Your Ref: BN/28/17/RES

Our Ref: NW/ARU/17/29B

RE. Land R/O Lillies Yapton Road Barnham PO22 0AY

Thank you for your correspondence of 15th December 2017, advising me of an Approval of reserved matters following outline consent BN/32/15/OUT relating to appearance, landscaping, layout & scale for erection of 38 No. dwellings including open space, landscaping & new access for which you seek advice from a crime prevention viewpoint.

Second Floor Plan

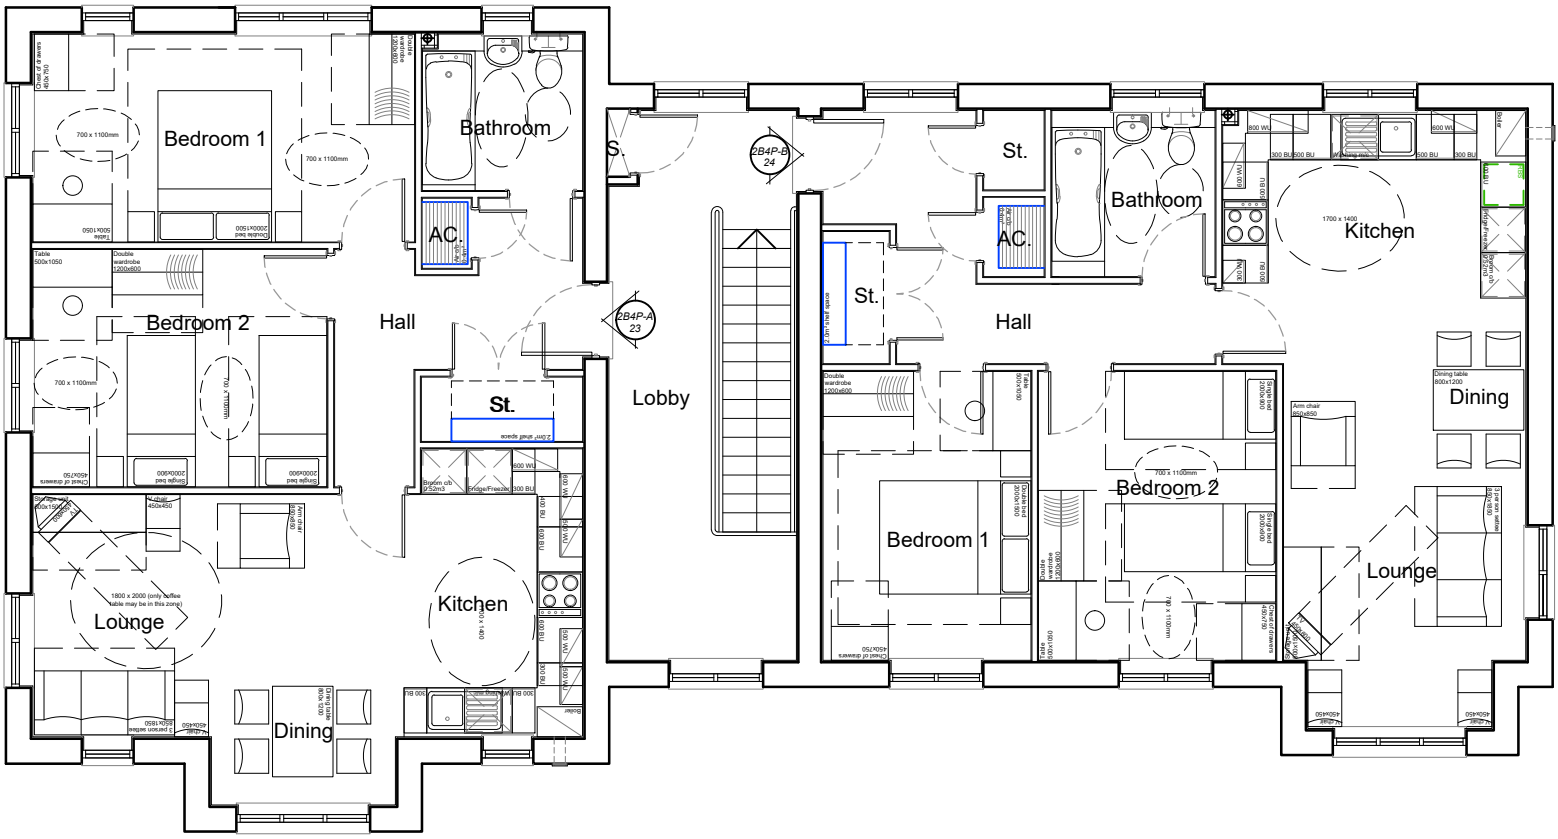
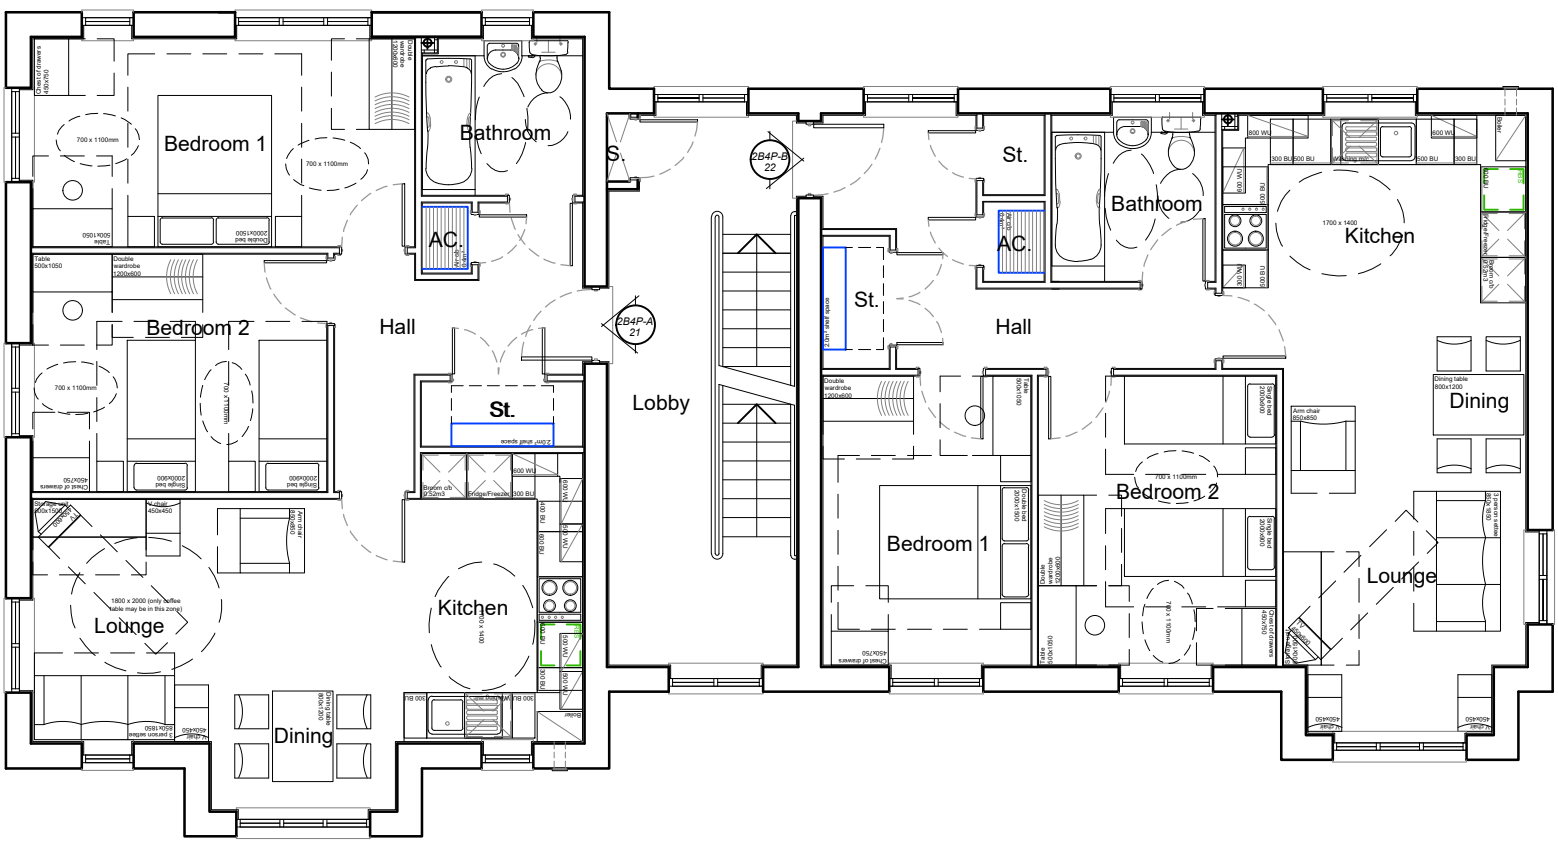
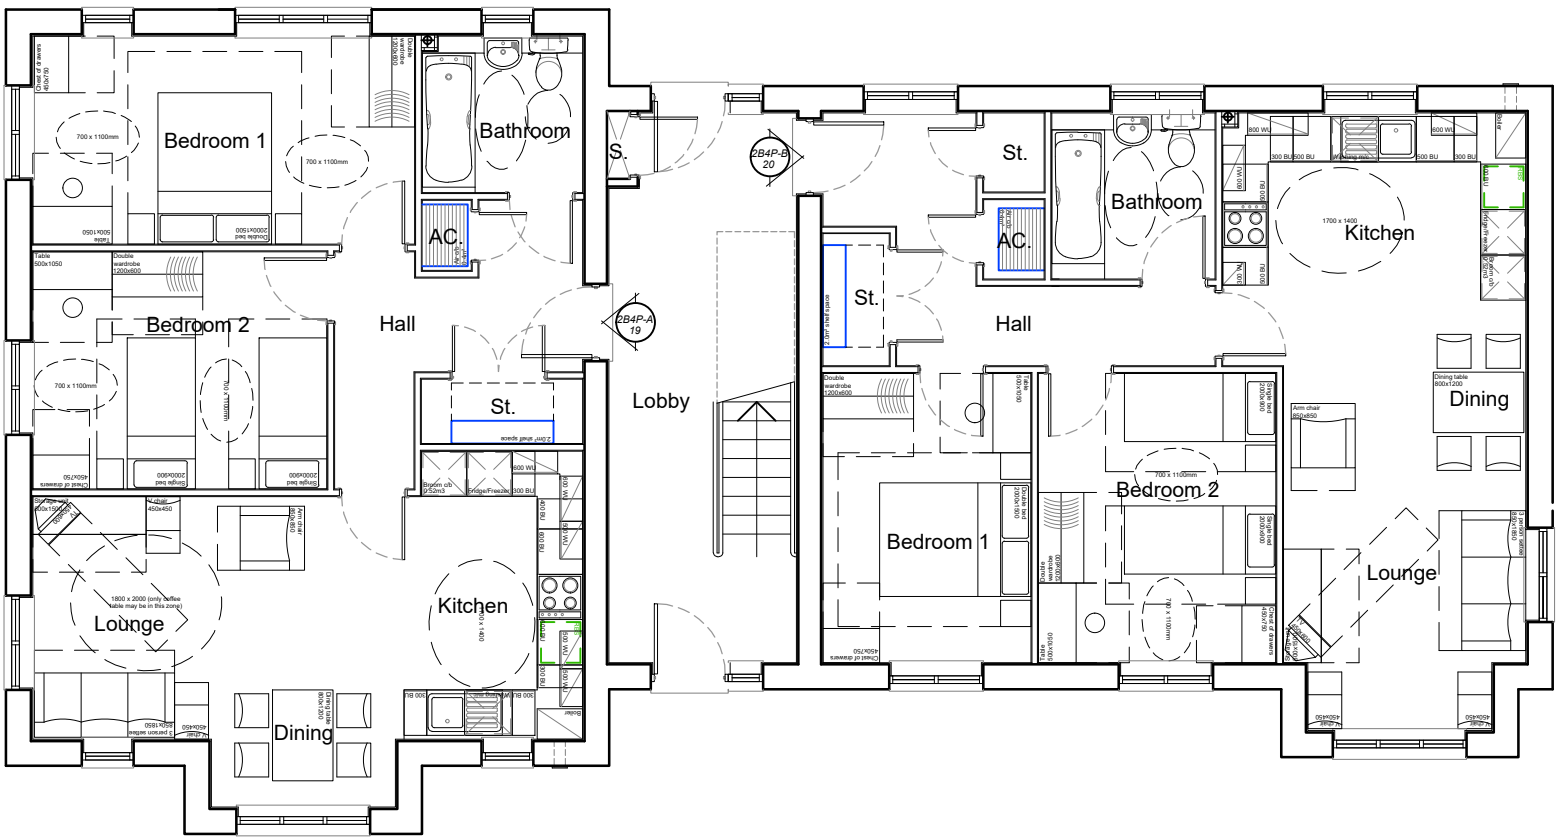
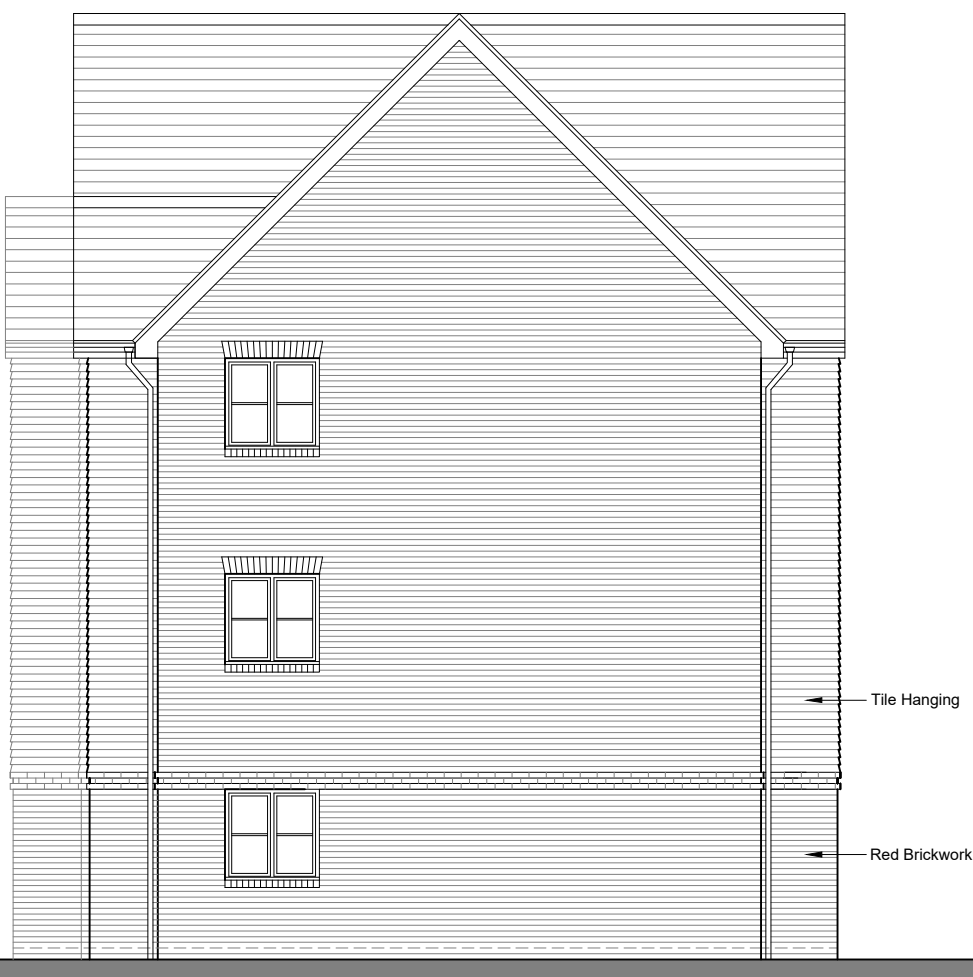
Communal entrance doors to the block of flats plots 19-24 that have a separate adjacent access control panel are usually subjected to greater use (and abuse) due to the number of dwellings served. Certification to one of the following standards can demonstrate that the door set has a more robust construction and is more able to withstand the day to day use in a communal application if tested to PAS 24:2012, PAS24:2016 or STS 201: / STS 202 Issue 3 (2011) Burglary Rating 2 (minimum) / LPS 1175 Issue 7.2 (2014) SecurityRating 2+ (minimum) / PAS 24:2012, paragraph 4.4.3 i.e. tested to BS EN 1627 Resistance Class 3

Individual internal front doors to the flats should meet PAS 24:2012 or PAS 24:2016 and be fitted with a door viewer and safety chain.

Any easily accessible windows within the residential parts of the flats should conform to PAS24:2012 specification with laminated glazing conforming to BS EN 356 P1A. (Easily accessible is defined within Building Regulations Document Q Appendix A as: A window or door set, any part of which is within 2 metres of an accessible level surface such as a ground floor or basement level or an access balcony.)

Minimum lighting specifications for the flats should include dusk to dawn vandal resistant switched lighting around the external entrances. Lobbies and internal foyers stair wells, stair cases and corridors should be fitted with PIR activated switched lighting.

I recommend the postal arrangements for the flats is through the wall, external or lobby mounted secure post boxes. I strongly urge the applicant not to consider letter apertures within the flats' front doors. The absence of the letter aperture removes the opportunity for lock manipulation, fishing and arson attack and has the potential to reduce unnecessary access to the block.
